**re: Geotechnical Review of Site Servicing Drawings**  
**Proposed Residential Development**  
**Chapman Mills Drive and Riocan Avenue - Ottawa**  
**to: Minto Communities – Mr. Carl Furney - [cfurney@minto.com](mailto:cfurney@minto.com)**  
**to: DSEL – Mr. Alex Tourigny – [atourigny@dsel.ca](mailto:atourigny@dsel.ca)**  
**date: June 27, 2023**  
**file: PG5636-MEMO.02**

Further to your request and authorization, Paterson Group (Paterson) prepared the current memorandum to provide a geotechnical review of the site servicing and grading plans prepared for the proposed residential development to be located at the subject site. The following memorandum should be read in conjunction with the current Geotechnical Investigation Report (Paterson Group Report PG5636-2 Revision 2 dated June 27, 2023).

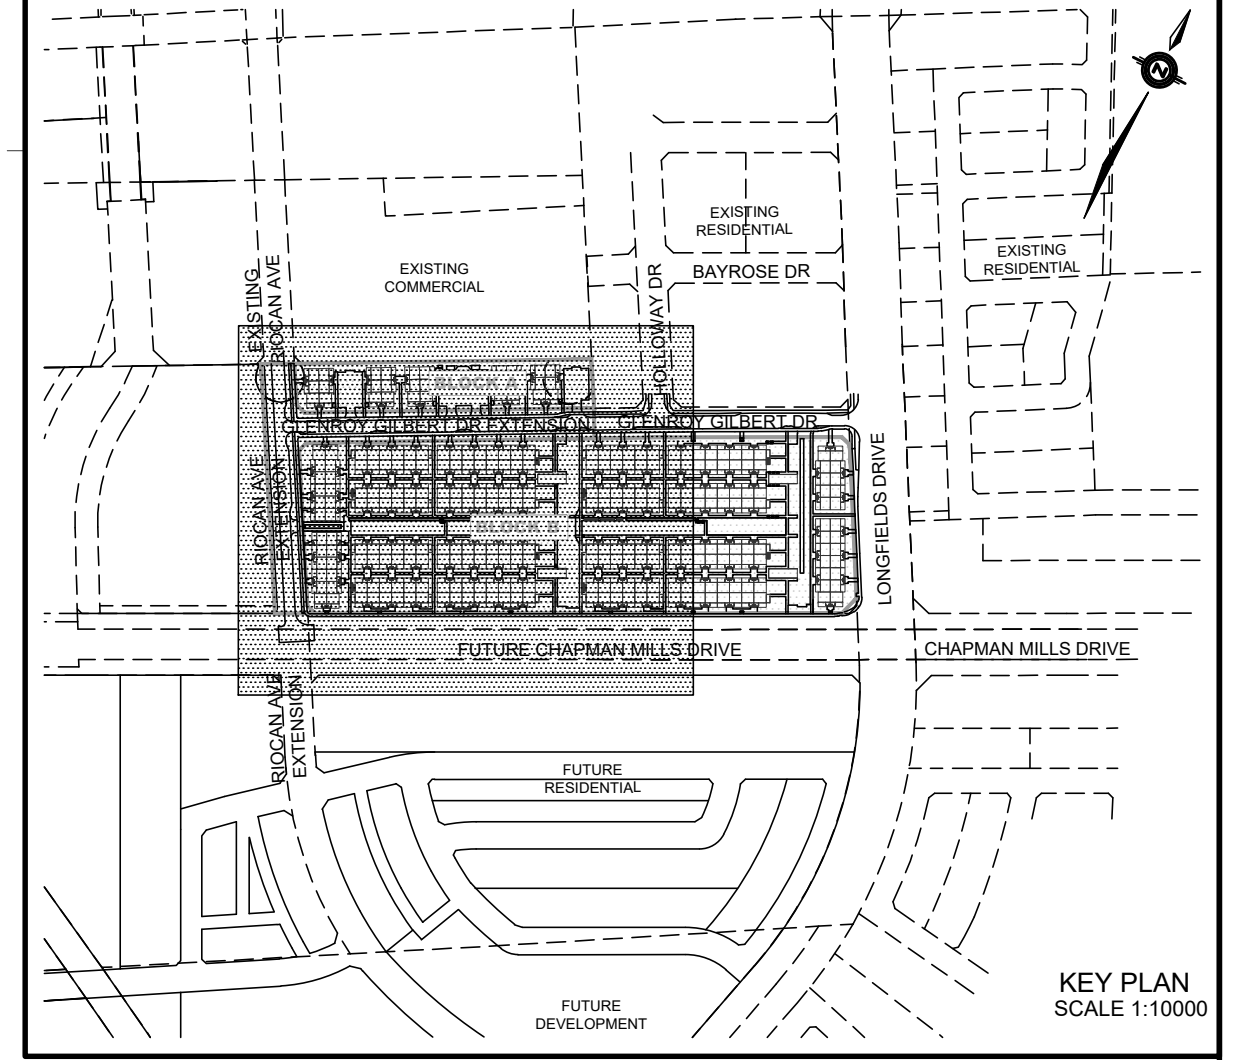
Based on our review, it is expected the depth of the basements for the townhouses that will be located above a parking garage structure will result in excavation footprints that extend into lateral support zones for buildings and services surrounding these structures. The extent of the potential undermining will depend on the size of the excavation undertaken without the use of a temporary shoring system. Further, it is expected the trenches undertaken for the storm alignment east of STM112 along Building 01 and the sanitary service between SAN143A and SAN 145A along Building 07 will undermine the lateral support zone for the adjacent structures.

Based on our review, the following recommendations could be considered for the placement of backfill around the perimeter of the future townhouses which will be provided a level of underground parking and where temporary shoring systems would not be considered:

- ❑ Suitable site-generated existing fill material, approved on-site by Paterson prior to use and expected to consist of relatively workable brown silty clay and/or glacial till can be using for backfilling against the building footprints. It is expected existing fill consisting of grey clay and/or fill with high organic (i.e., stumps, logs, peat, etc.) and deleterious material (inorganic debris, non-soil fill material) content would not be suitable for re-use.

- ❑ Grey silty clay is not expected to be considered acceptable for this purpose. Cobbles and stones larger than 200 mm in diameter should be segregated from the fill prior to re-use. Other deleterious materials not considered suitable for re-use will be determined and be requested to be removed from being segregated at the time of construction by Paterson personnel. The site-generated fill considered for this purpose should be reviewed and assessed by Paterson personnel at the time of segregation/excavation and as coordinated with the site's earthworks contractor.

- ❑ Site-generated fill, approved by Paterson personnel, should be placed in maximum 300 mm thick loose lifts and compacted using a suitably sized vibratory sheepsfoot roller to backfill around the proposed structures back to the existing ground surface. The re-use fill material should be compacted by several passes of a suitably sized vibratory sheepsfoot roller (i.e.- 5 to 6 passes and as deemed appropriate by Paterson personnel at the time of construction).

- ❑ All material should be placed in **dry and above-freezing conditions**. Frozen material may not be considered for this purpose. This process should be reviewed and approved daily by Paterson field personnel during the placement of the fill layers.

- ❑ At the time of construction for the proposed building footprints that would overlies the previously backfilled excavation for the parking garage structures, it would be recommended to sub-excavate a minimum 500 mm below design underside of footing. The subgrade should be then proof-rolled with a suitably sized sheepsfoot roller and reviewed at the time of proof-rolling by Paterson personnel. Once approved, the sub-excavation may be in-filled with engineered fill, such as OPSS Granular A or OPSS Granular B Type II crushed stone, placed in maximum 300 mm thick loose lifts and compacted to a minimum of 98% of the materials SPMDD.
